Land at Ford Airfield. Response to Phlorum Odour Assessment Review and Southern Water Comments.

This Technical Note has been prepared by Hoare Lea with support of Air Pollution Services. It provides a brief commentary on the Phlorum report commissioned by Arun District Council (ADC) that reviews the quantitative odour assessment undertaken by Hoare Lea for the planning application (ref: REP-1010502-5A-20211019-Ford Airfield Odour-R7) for Land at Ford Airfield, Ford, West Sussex (F/4/20/OUT) (Phlorum, Odour Assessment Review, Land at Ford Airfield, Ford, West Sussex, November 2021, Report number 11050).

This note also comments on Southern Water's reasons for objecting to the planning application in their letter to ADC dated 24th November 2021 (Southern Water ref: PLAN-040929).

- Site Boundary
- 100m Calm Buffer
- 1.50uE/m³ Contour (Average)
- 3.0uE/m³ Contour (Average)
- 5.0uE/m³ Contour (Average)

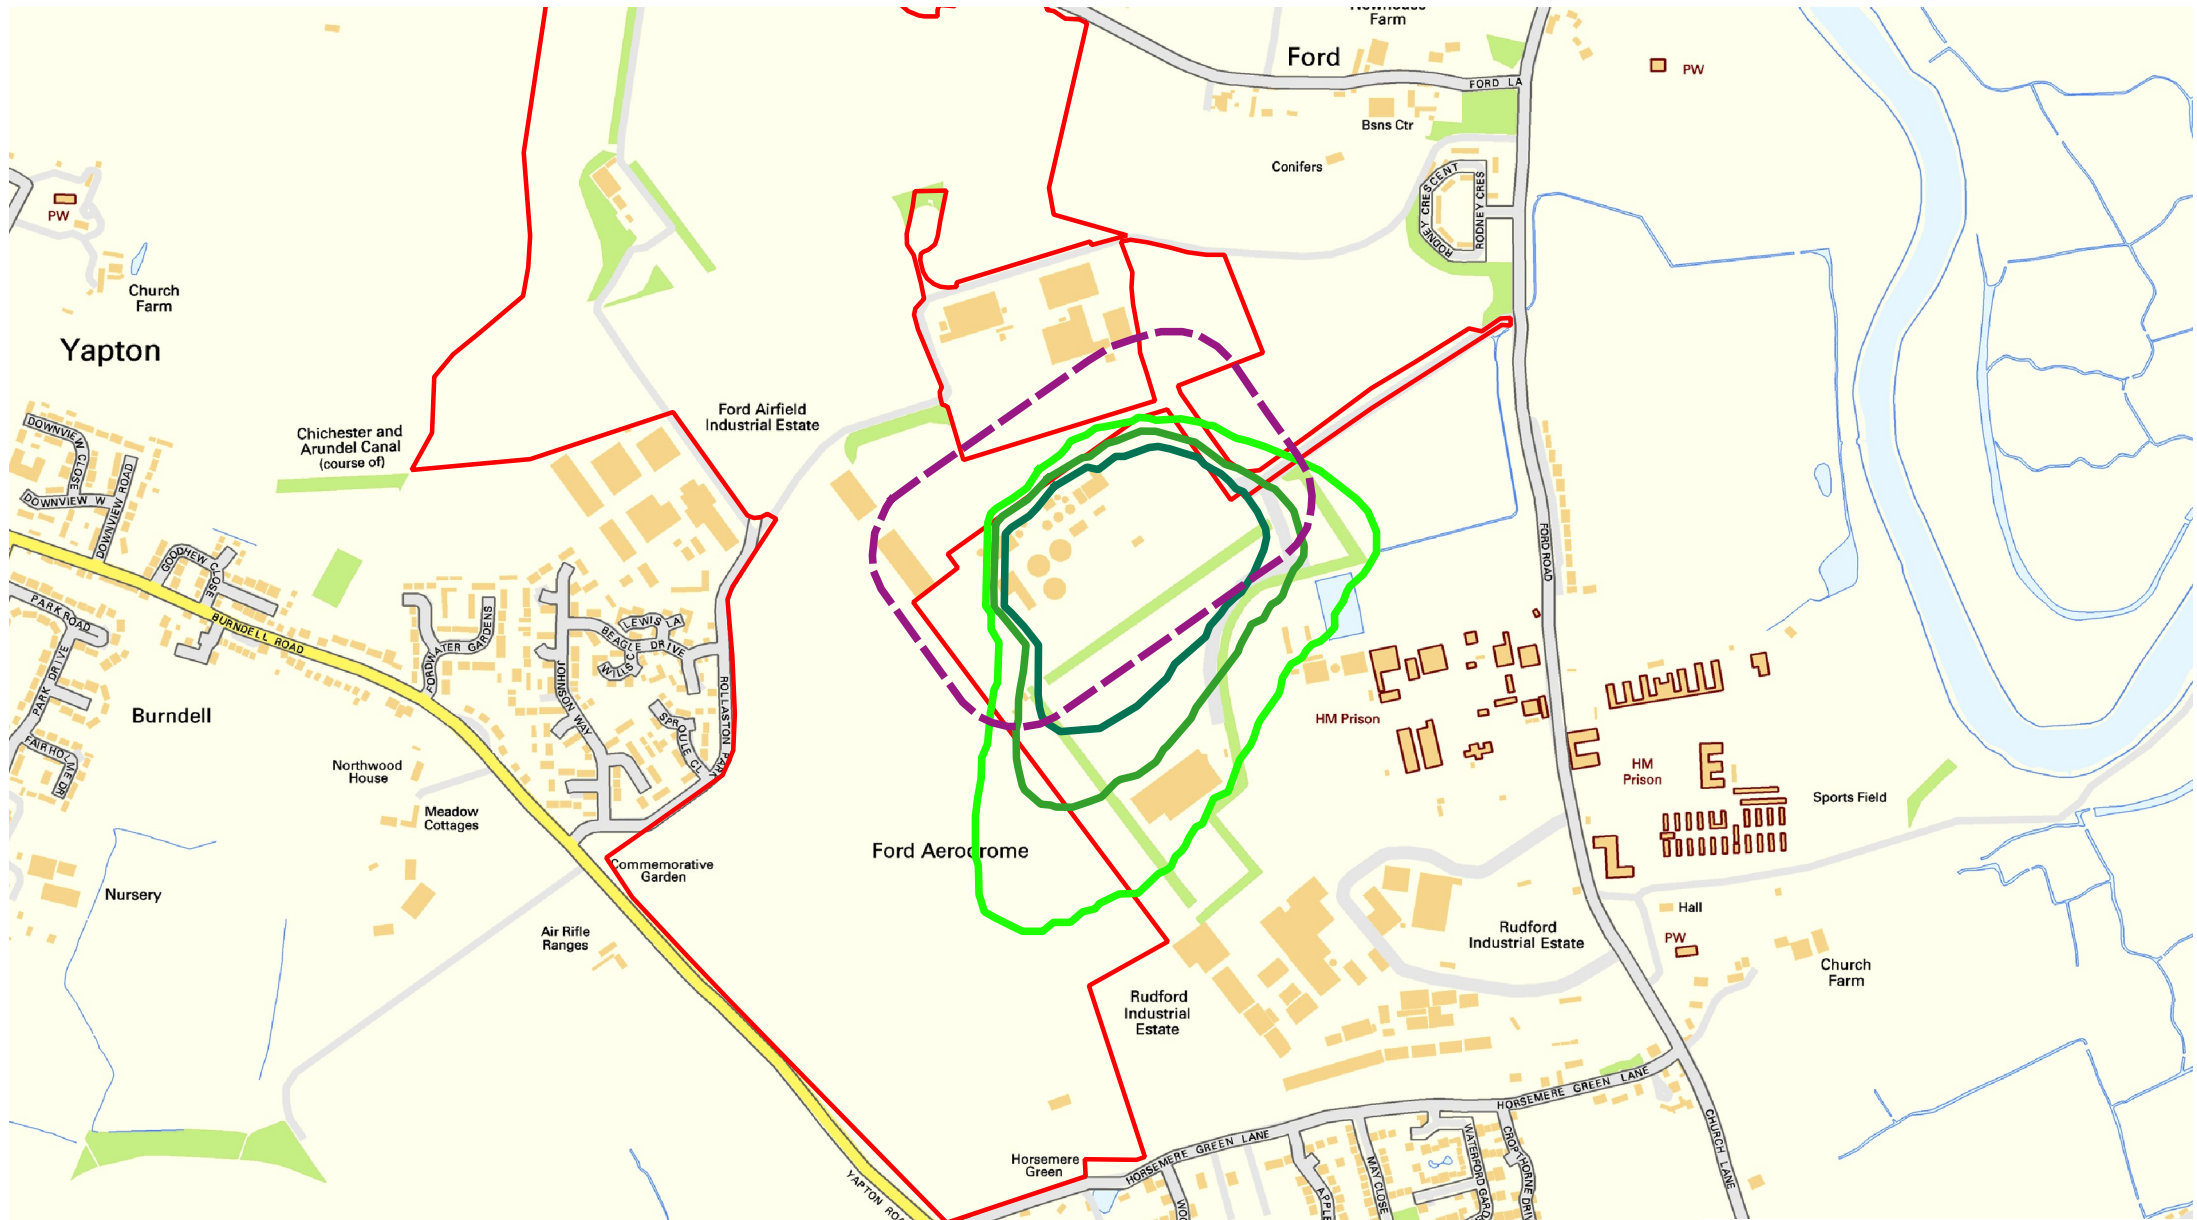
- Why the odour contour extends further to the south than north-east; and
- How the sniff tests have been used to inform the masterplan and whether the cordon sanitaire around the WwTW has been defined solely based on the results of the dispersion model.

The wind rose (Figure 5-1 of REP-1010502-5A-20211019-Ford Airfield Odour-R7) shows that south westerly winds are more common than northerly winds. The odour contours from the dispersion modelling (Drawings AQ 3 and AQ4 of REP-1010502-5A-20211019-Ford Airfield Odour-R6 Appendices) show the impact of the WwTW emissions are largely in the southerly direction.

Although the wind rose presented in Figure 5-1 of the quantitative odour assessment illustrates a strong wind component from the southwest, the northern component has a significantly higher frequency of low wind speeds. Low wind speeds cause the greatest odour effects since odours get dispersed quickly with higher wind speeds. The modelling, which uses the 98th percentile concentrations, thus aligns with the meteorological data, such that the odour contours show a larger extent to the south, where low wind speeds from the north will cause the greatest effect.

The maximum distance from the most odourous parts of the WwTW that any of the surveys showed a moderate or substantial adverse impact was 325m. In the area 325m south of the most odourous parts of the WwTW, no residential units are proposed within the Masterplan and this is within the 'cordon sanitaire' identified by the dispersion modelling.

The Masterplan for the Ford Airfield development was based broadly on the results of the dispersion modelling. No residential development is within 100m of WwTW to account for the fact that the dispersion model cannot account for calm weather conditions. In these conditions the odour will not generally disperse far from the source. In defining the location of the residential areas the Masterplan broadly follows, or is outside, the maximum $3 \text{ OUE}/\text{m}^3$ contour derived from the maximum 98th percentile concentration in each of the five years modelled.
